Our Case Number: ABP-314724-22

Re: Railway (Metrolink - Estuary to Charlemont via Dublin Airport) Order [2022]
Metrolink. Estuary through Swords, Dublin Airport, Ballymun, Glasnevin and City Centre to
Charlemont, Co. Dublin

RE: SUBMISSION ON THE METROLINK RAILWAY ORDER APPLICATION IN
RELATION TO THE SITE OF A COMMERCIAL DEVELOPMENT AT 2 GRAND
PARADE, RANELAGH, DUBLIN 6.

AN BORD PLEANÁLA REFERENCE: NA29N.314724

Client	TII NTA	Project	METROLINK	Drawing Title	METROLINK - STRUCTURES CHARLEMONT STATION PROPOSED STREET LEVEL DESIGN	Drawing Status	S0
Consultant	JACOBS IDOM	Drawing N°	ML1-JAI-SRD-ROUT_XX-DR-Z-02090	Plan Drawing N°	ML-ST 307 O-A1		
		Scales Original Size A1	1:250			Sheet	1 of 6

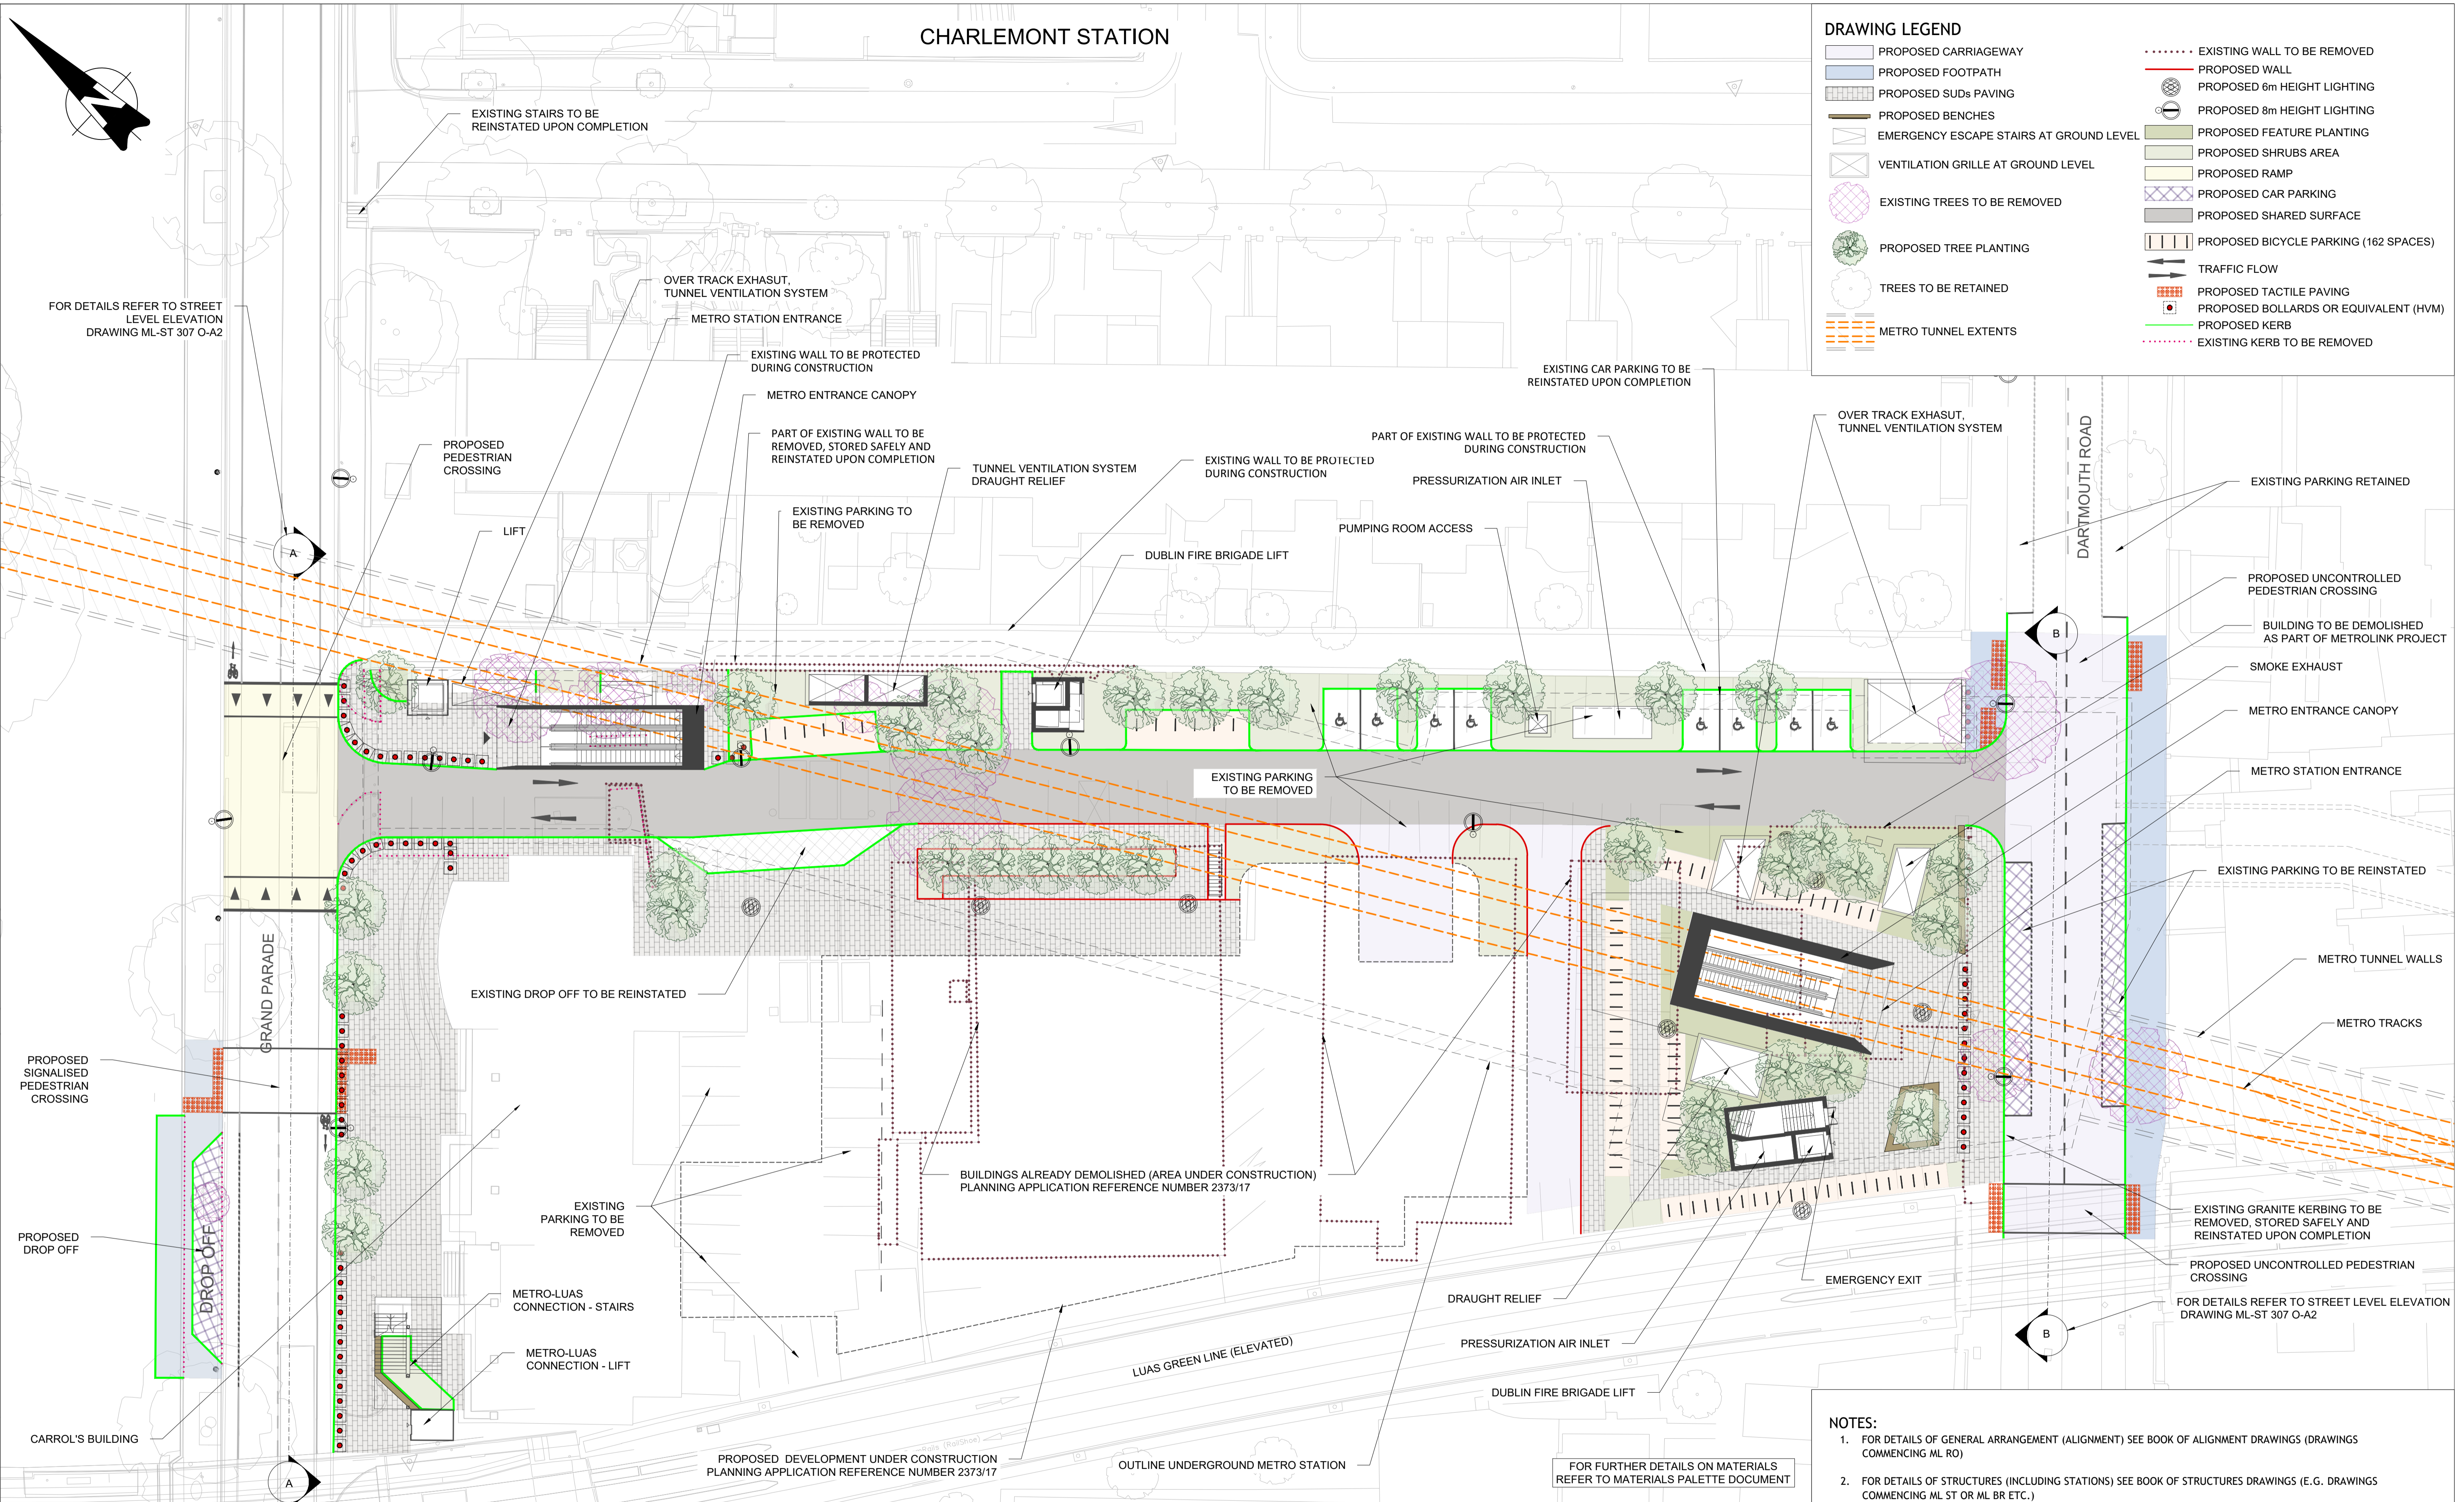
It is proposed to provide a Metro-Luas connection lift and stair to the northwest of the Carrolls Building within the 2 Grand Parade site.

As set out in the accompanying HJL Architects report (Appendix 1), and further elaborated on in the MSA Technical Note (Appendix 3), the location and design of this stairway and lift access would negatively impact on our client's development at 2 Grand Parade as follows:

- The structure would obstruct designated fire escape routes from the 2 Grand Parade development,
- There would be an additional risk of fire spread in the event of a fire due to proximity to the existing building.

Having regard to the foregoing, it is submitted that the lift shaft should be relocated to an alternate location (potentially the opposite side of Grand Parade adjacent to the Grand Canal) and the staircase proposed should be reconfigured to address the concerns raised.

- Part of the permitted 2 Grand Parade scheme is a 6m roadway to access the development (with the width of the access based on two-way car traffic, fire access, cyclists, and to accommodate perpendicular parking). The escalators proposed would reduce the width of the access to an extent which would interfere with the accessing of the development.

- The design currently does not indicate a kerb along side the escalators (which would be required) and this would further obstruct the access to the 2 Grand Parade development.

- In this regard the DBFL technical note sets out that the minimum width considered acceptable by our client would be 5.5 metres for the carriageway, with a 2 metre footpath provided in addition to this.

- In addition to this, the MSA note states that this aspect of the design would have an adverse effect on escape from the 2 Grand Parade development via stair core 2.

The HJL submission report (Appendix 1) sets out that there is intended to be a raised table junction at the access to the 2 Grand Parade development from Grand Parade to the west.

The HJL document notes that further details are required in relation to the level of the raised table interface with the adjacent public road and the 2 Grand Parade access.

Additionally, a significant number of bollards are indicated along the frontage to Grand Parade and along the 2 Grand Parade access road. It is noted that some of these bollards would impinge on fire escape from stair core 2 of the Carrolls Building, and additionally it is noted that there are already several trees permitted along this frontage as part of the permitted 2 Grand Parade development.

Furthermore, it is noted that a new pedestrian crossing will be provided crossing Grand Parade and aligning with the main entrance to the 2 Grand Parade development. Clarification is required in relation to the details and finishes for the adjacent paving and the paving at the entrance to the 2 Grand Parade development. Clarification is also required on the anticipated pedestrian flows associated with this crossing, noting that Charlemont is predicted to be one of the busiest stations on the MetroLink line (with predicted peak passenger numbers boarding and alighting of over 2000 and almost 4000 respectively by 2065).

As set out in Appendix 1, to the west of the access road, it is proposed to provide over track exhaust tunnel ventilation systems adjacent to the Dartmouth Square boundary of the 2 Grand Parade site, and adjacent to the Dartmouth Road entrance, a pressurized air inlet pumping room access, a Dublin fire brigade lift and a tunnel ventilation system draught relief structure are proposed. This will result in a reduction from 14 to 8 no. car parking spaces at ground level. These structures are also located at the location of a brick boundary wall which is protected fabric. It is therefore requested to consider an alternative for these structures.

Finally, it is proposed to provide bicycle parking spaces to the south of the 2 Grand Parade Building, at the location of a designated fire escape access and egress route from stair core 1 within the development under construction, which would result in an important fire escape route being compromised, and also potentially impact on access to ESB substation rooms at this end of the 2 Grand Parade building. It is requested therefore that this bicycle parking be altered to avoid impinging on this route. A revised design in this respect should be submitted prior to the granting of a Railway Order.

Having regard to the foregoing, revisions should be made to the Railway Order application drawings and documents, to ensure that a minimum 5.5 metre carriageway and a 2-metre paved footpath to maintain adequate access (including fire access).
